From: Nicola Clark
Sent: 28 March 2019 17:51
To: Adrian Dowd
Cc: planning
Subject: 3/2019/0060

Internal refurbishment including kitchen fit out, new rear door, internal screen removal and new lightweight screen, removal of reception desk and new internal door, relocation of cellar door, formation of essential opening between bars, new door to external seating area, repairs to garden walling and fence to tanks area, altered decking with new roof, minor alteration to entrance porch, redecorations and bathroom refurbishment to first floor.

**TITLE: Proposed Ground Floor Plan**

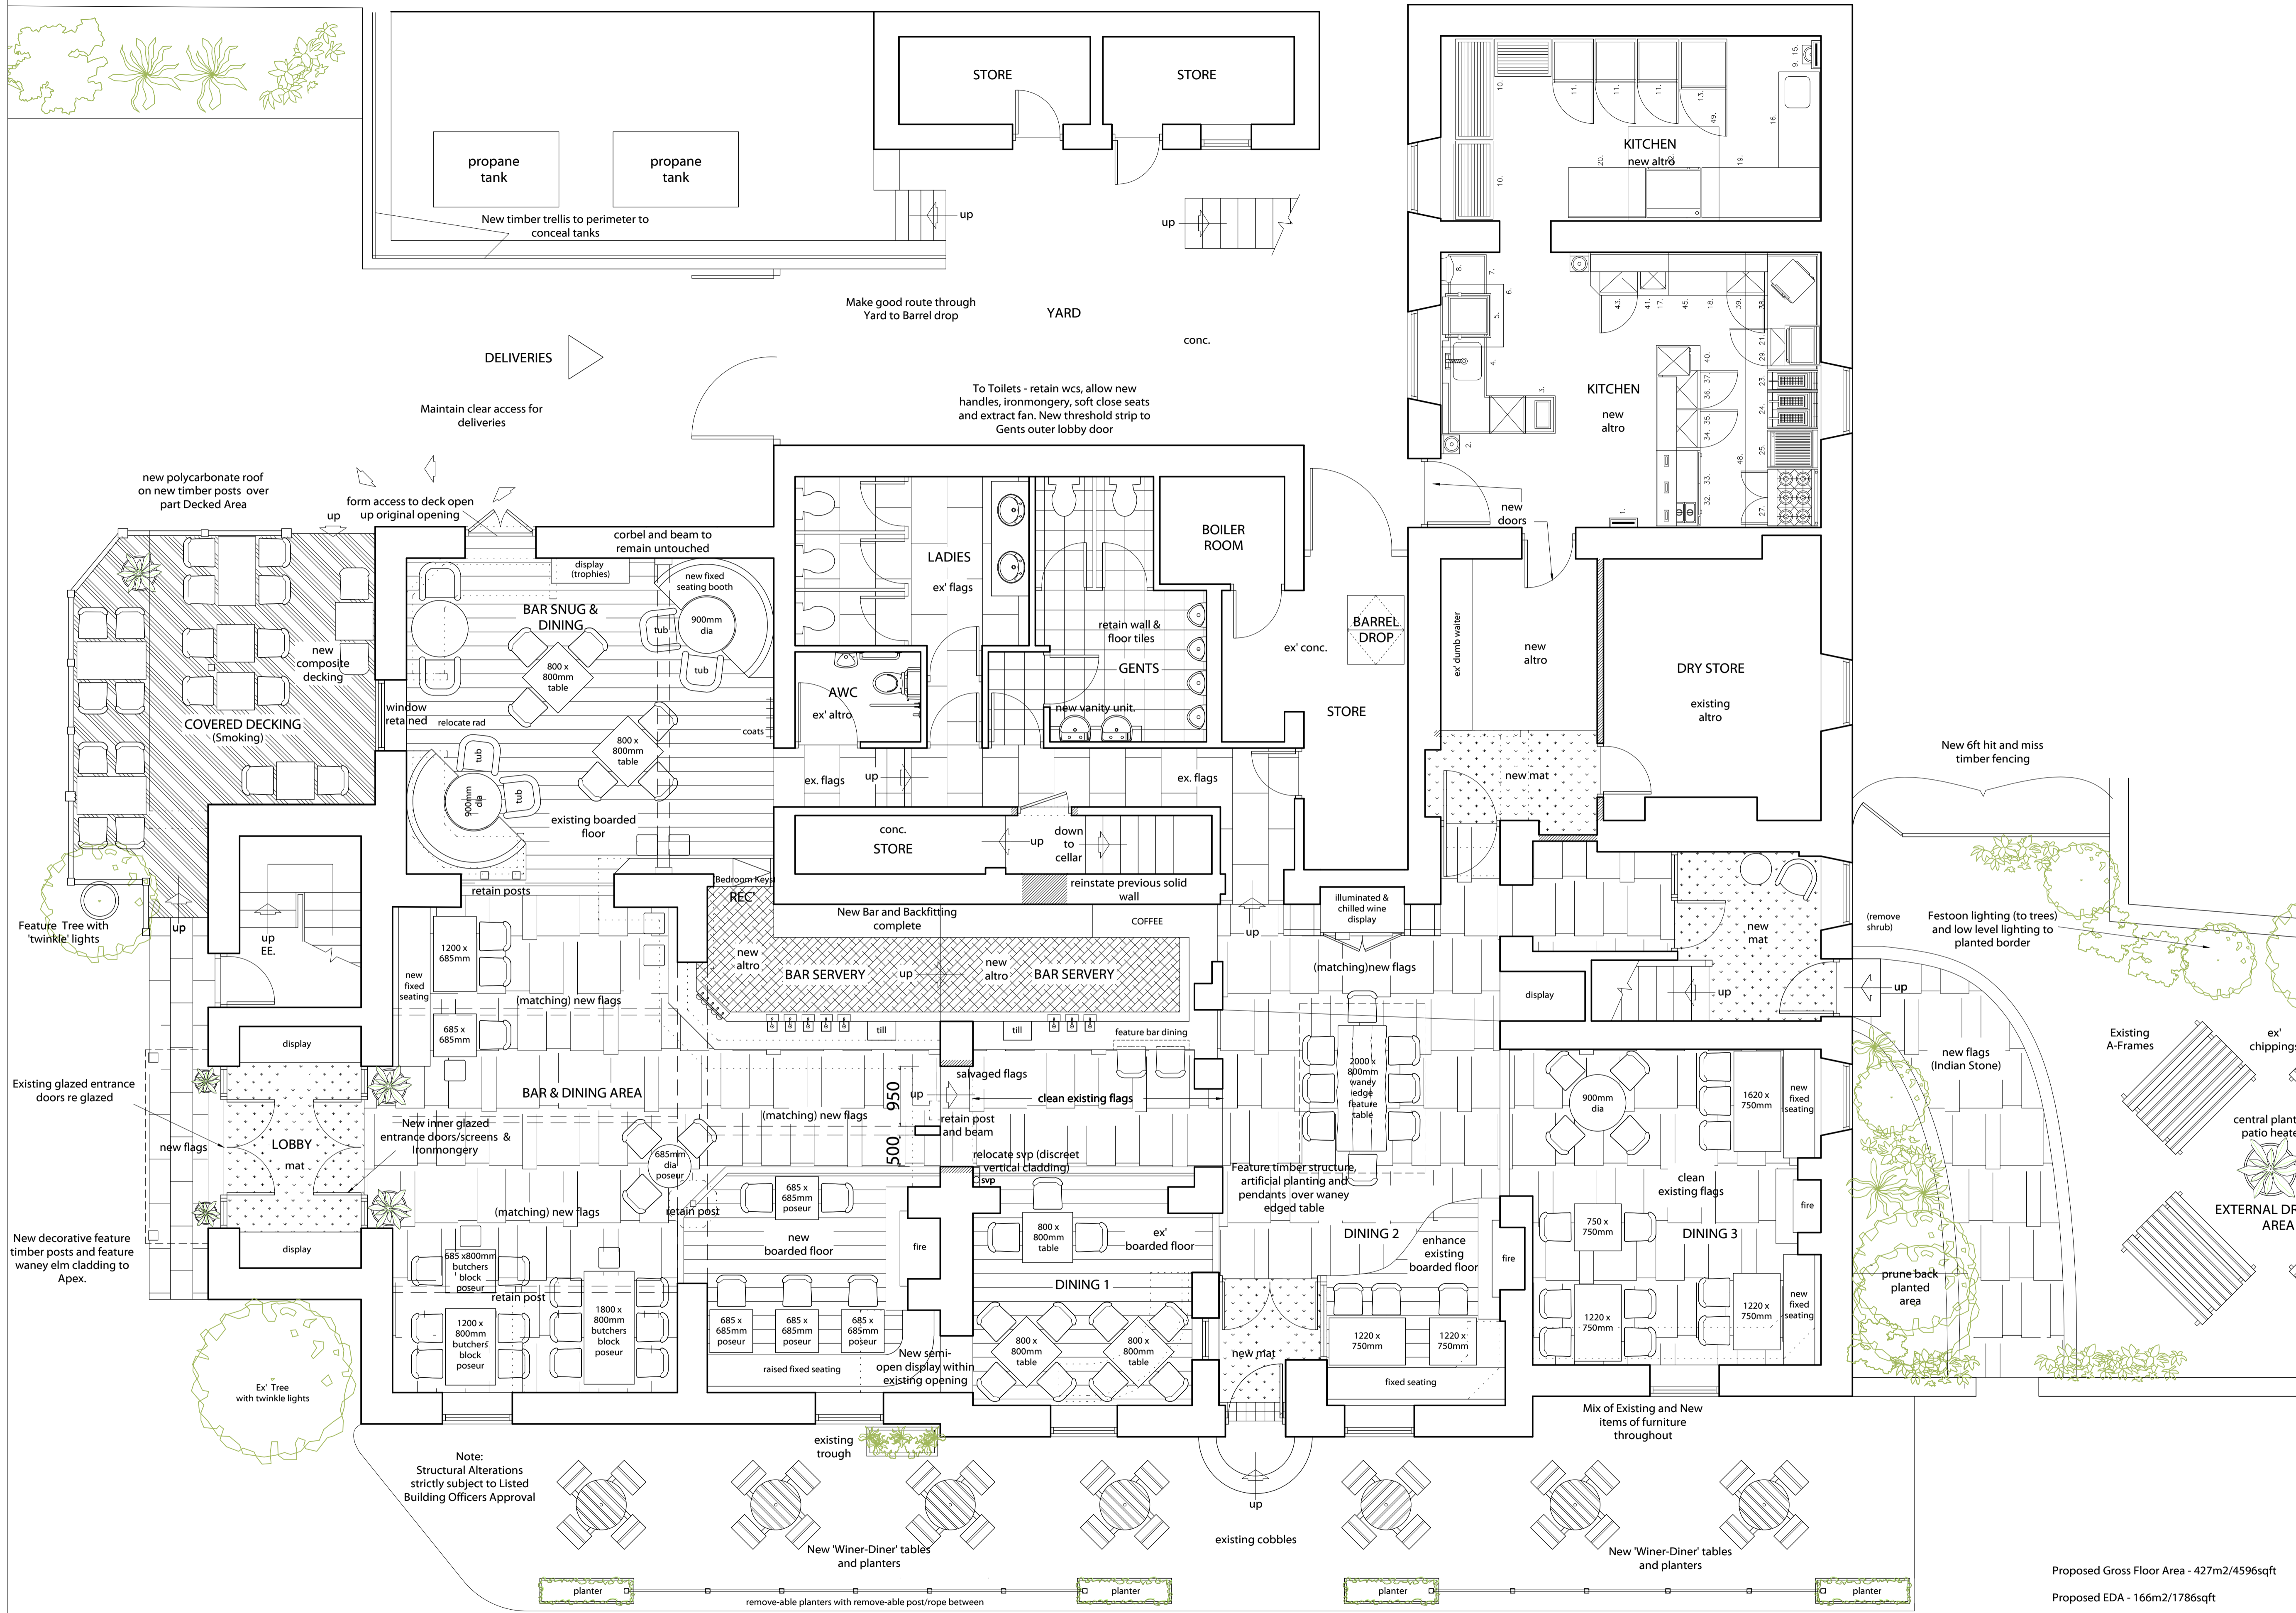
I have reviewed the application and I have concerns that the proposed increase in size for the external beer garden may cause an adverse impact on the occupiers of nearby sensitive premises owing to increased noise levels.

Therefore, I would ask that the beer garden is closed at 22.00 hours each day, and that no recorded or live music of any kind is played in this area. On this basis, I would have no objections to the planning application being granted.
